WEST SUSSEX COUNTY COUNCIL CONSULTATION

TO:	Arun District Council FAO: Andrew Wood
FROM:	WSCC - Highways Authority
DATE:	15 October 2019
LOCATION:	117 Elmer Road Bognor Regis PO22 6LH
SUBJECT:	M/42/19/PL Demolition of existing dwelling & erection of pair of semi-detached chalet dwellings with on-site parking facilities & new vehicular access.
DATE OF SITE VISIT:	n/a
RECOMMENDATION:	Advice
S106 CONTRIBUTION TOTAL:	n/a

Ground floor plan

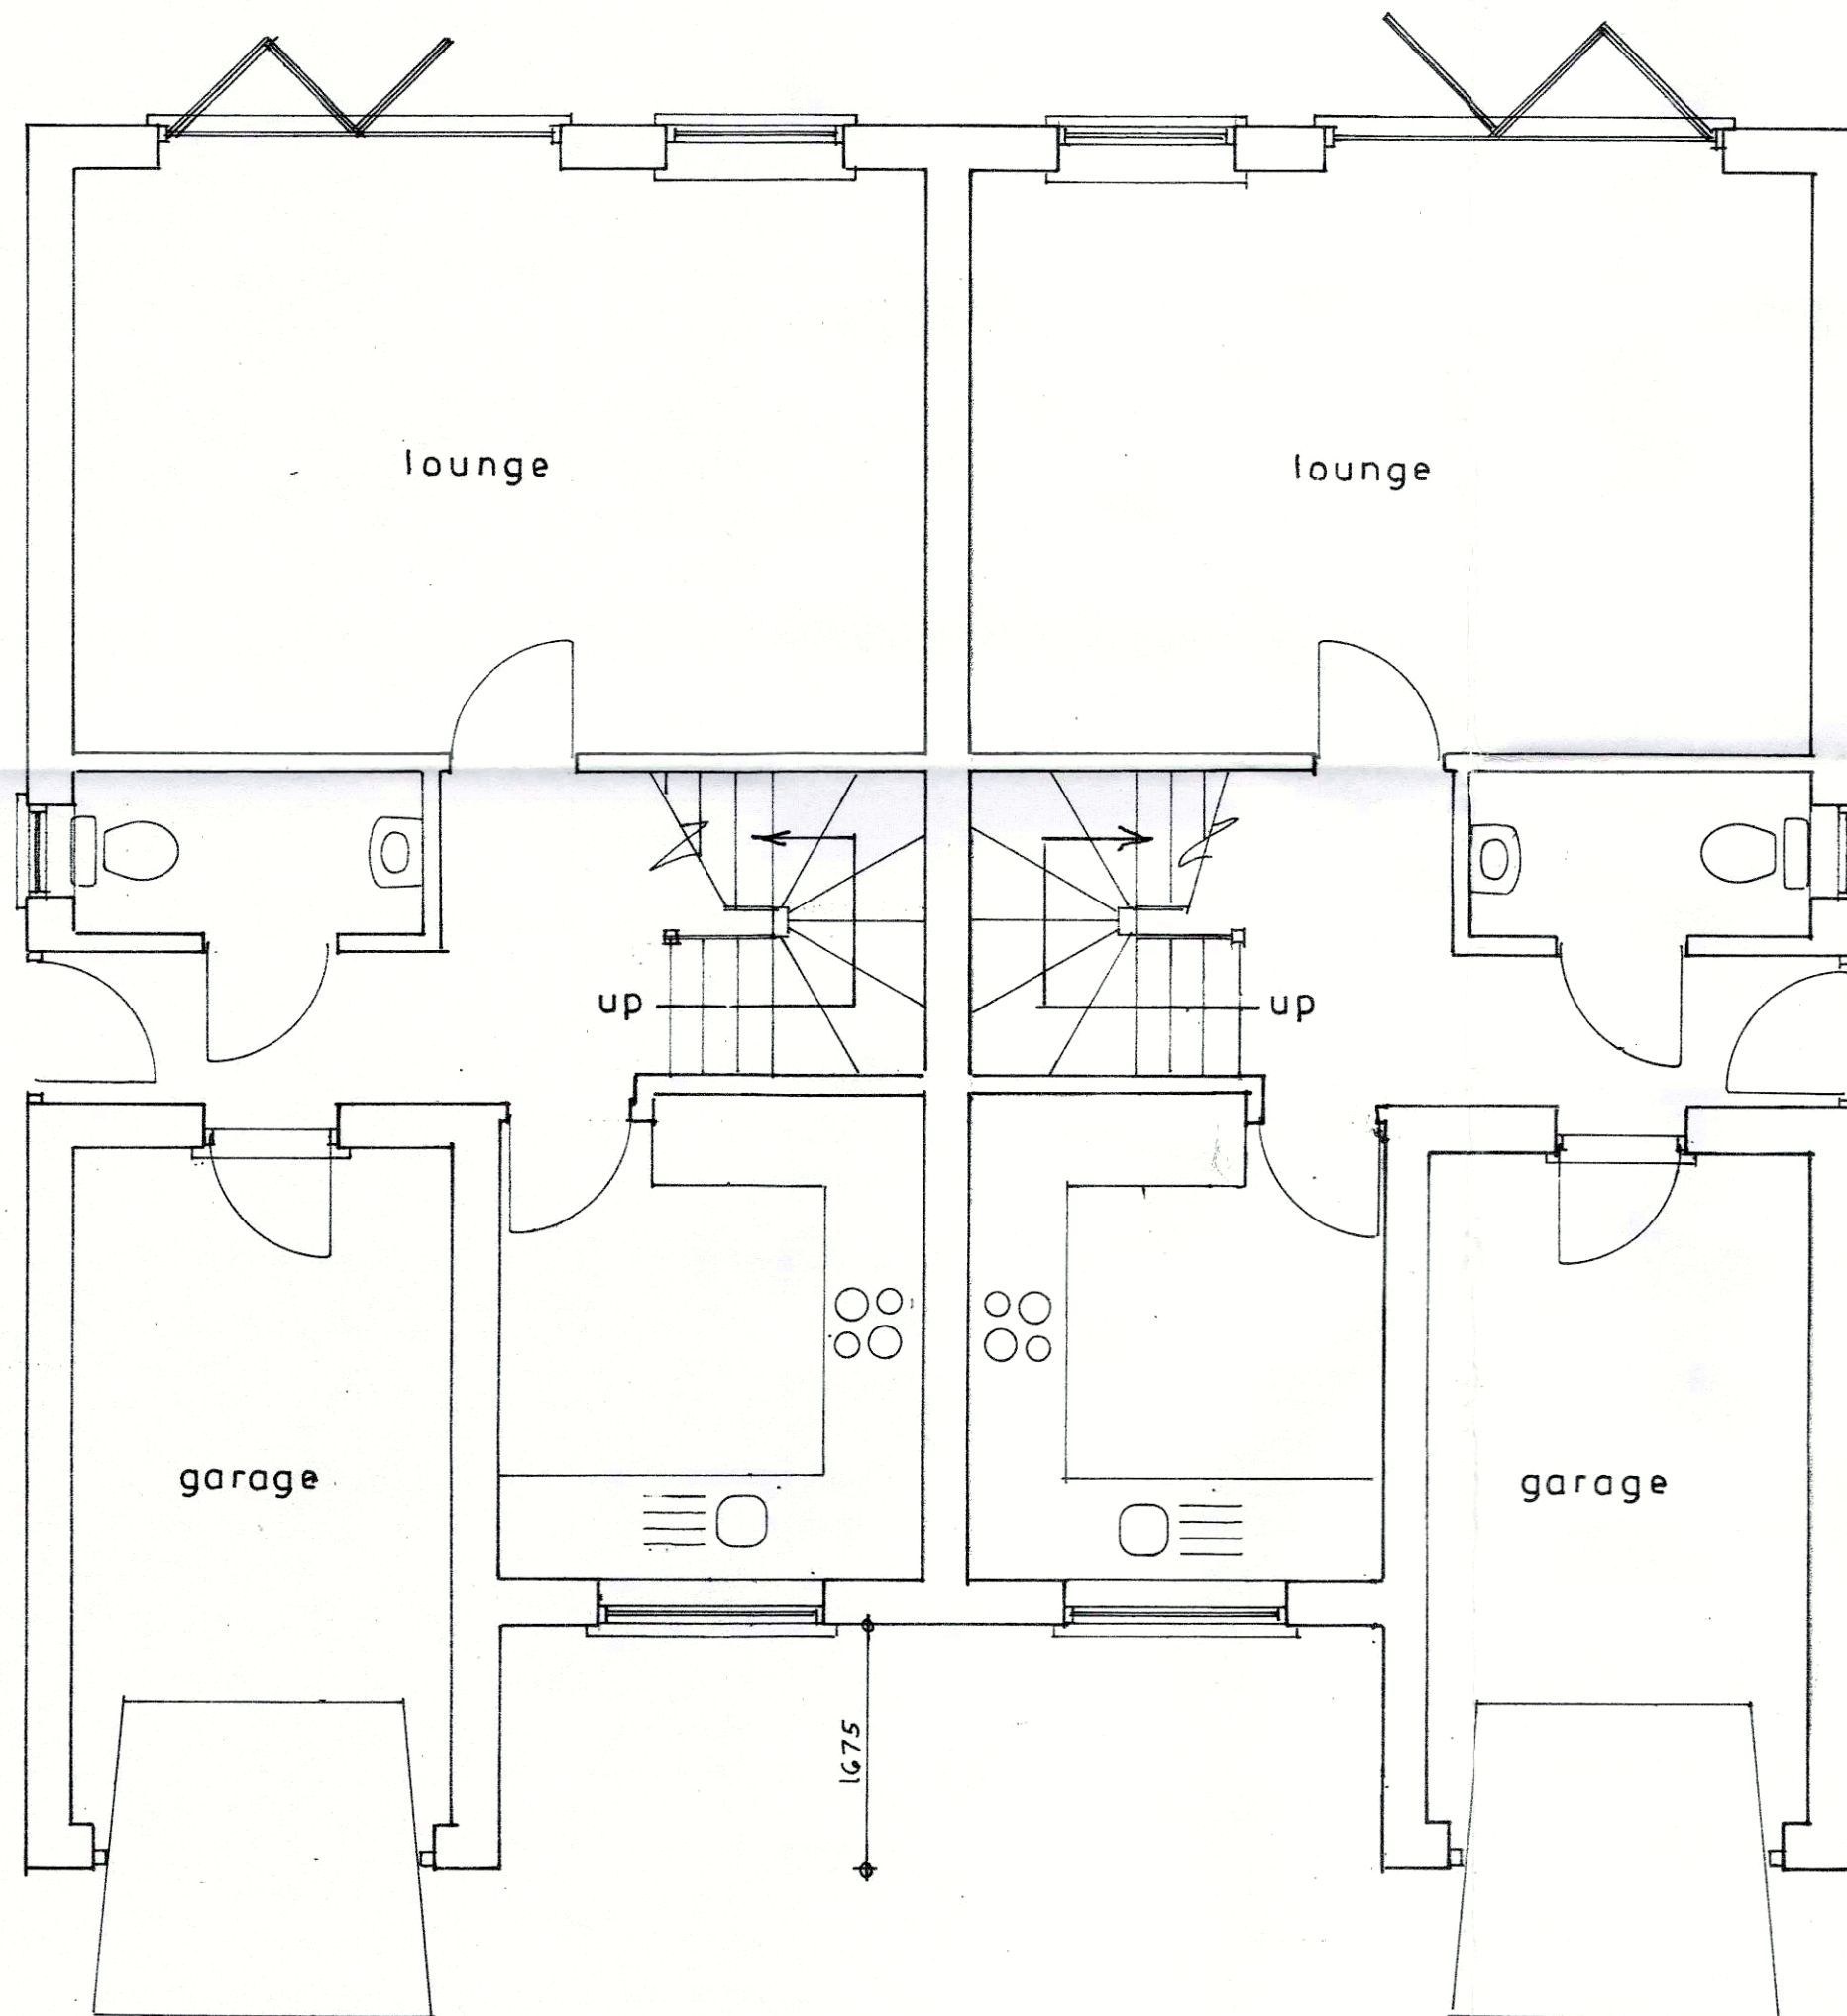
The applicant has demonstrated that each house will benefit from a garage measuring 2.5 x 4.5 metres. This does not conform to WSCC and MfS guidance and will not be counted towards cycle or parking demand.

parking & vehicular access

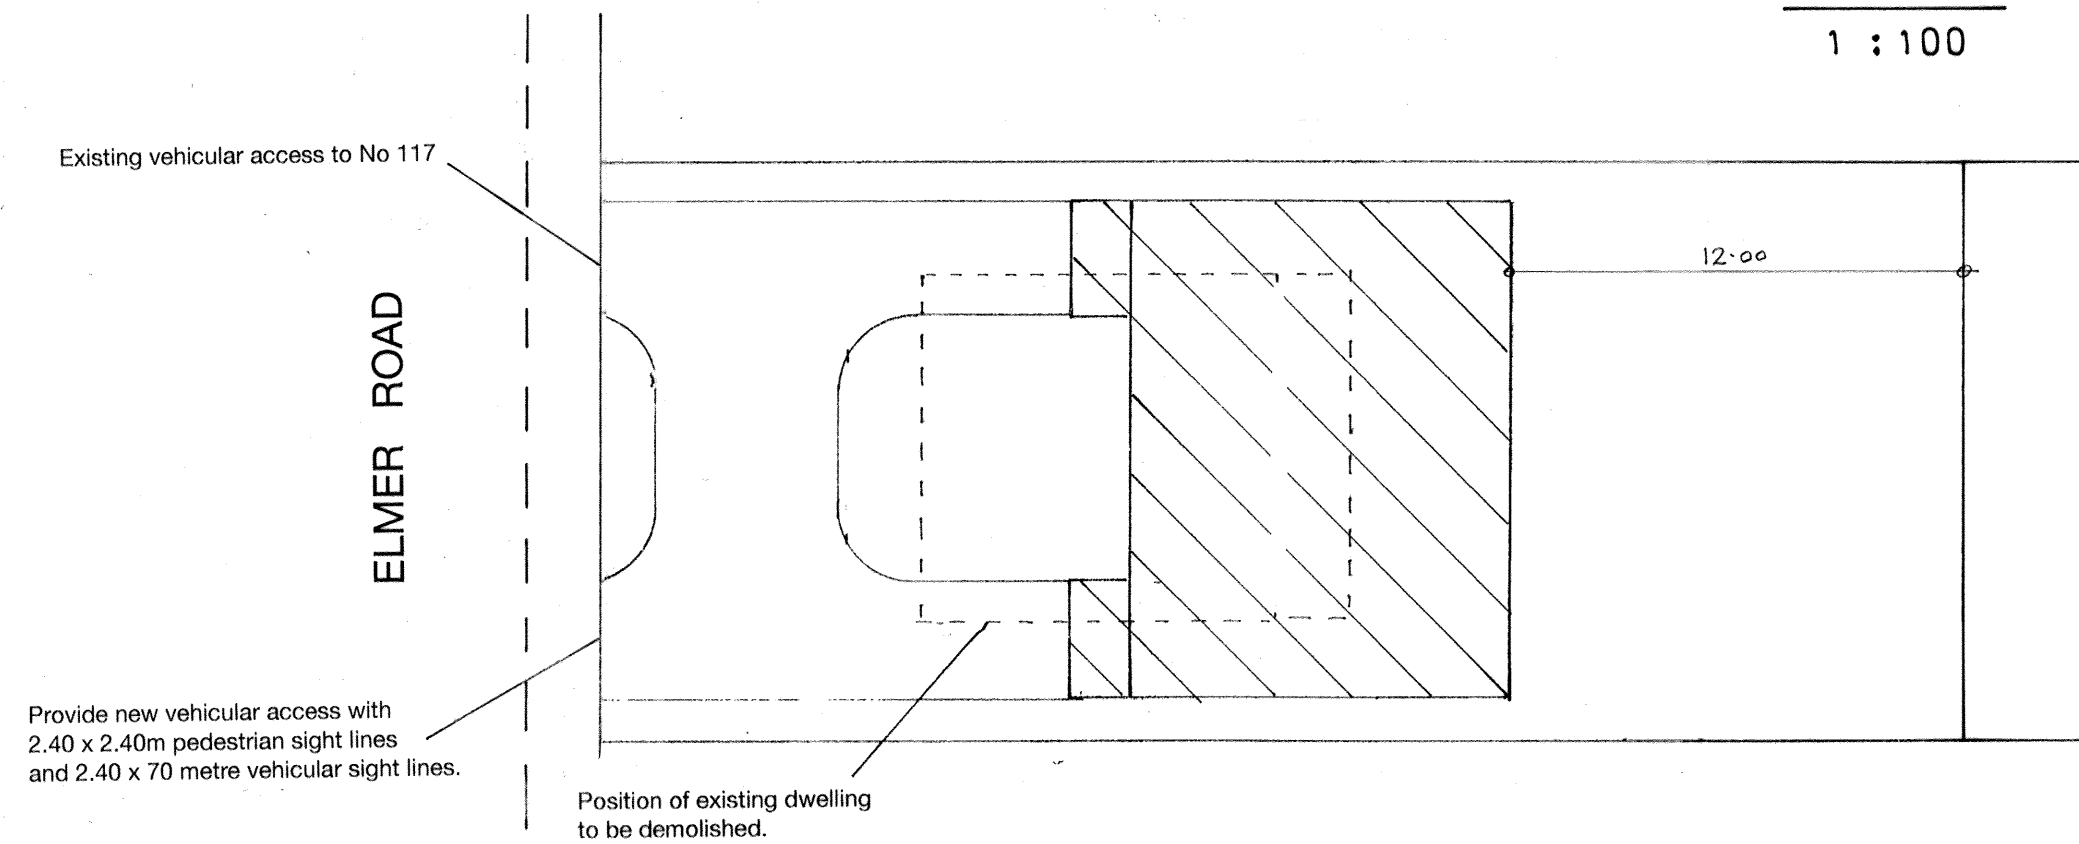
2. The applicant has failed to demonstrate the VCO dimensions, but after inspection of WSCC local mapping and the submitted plans the LHA observe that the proposal includes a new 6.8 metre VCO at the eastern extent of the site.

3. The applicant has failed to demonstrate maximum achievable visibility splays on the plans. However from an inspection of WSCC and local mapping visibility upon Elmer Road is sufficient with excess of 2.4m by 43m available from the centre of the proposed access point, within maintainable highway land. Manual for Streets sets out that 43m is suitable stopping sight distance (SSD) for vehicle speeds of 30 mph and therefore the LHA do not raise concerns regards the proposed location of the access point.

4. It should be noted that while the applicant states that the site will benefit from pedestrian splays of 2.4 x 2.4 metres, upon inspection of the plans and WSCC local mapping the LHA state that these would not be achievable due to 3rd party land. MfS states that in the absence of pedestrian visibility, occupiers of motor vehicles will emerge from the back of the footway in a cautious manner, on the flip, in locations where VCO are presence pedestrians using the footway do so in a cautious manner. The LHA will NOT seek these to be submitted.

5. After inspection of the plans the LHA note, the frontage of both garages appear to benefit from a parking area large enough to accommodate 1 vehicle each.

The applicant has demonstrated an 'In out' style drive that will allow future occupiers of the 2 dwellings the ability to turn within the site and enter the publicly maintained highway in a forward gear.

The anticipated demand for 2 dwellings of this size and location would be 3 spaces. The LHA is mindful that the site layout would allow for tandem parking of 2 cars per dwelling. As such an appropriate quantity of parking can be accommodated on site. The LHA accepts that such parking would prejudice the proposed turn on site, however given the nature of Elmer Road this would not be considered an overriding concern.

The use of the parking area shall not commence until the vehicular access serving the development has been constructed in accordance with the approved site plan.

No part of the development shall be first occupied until the car parking has been constructed in accordance with the approved site plan. These spaces shall thereafter be retained at all times for their designated purpose.
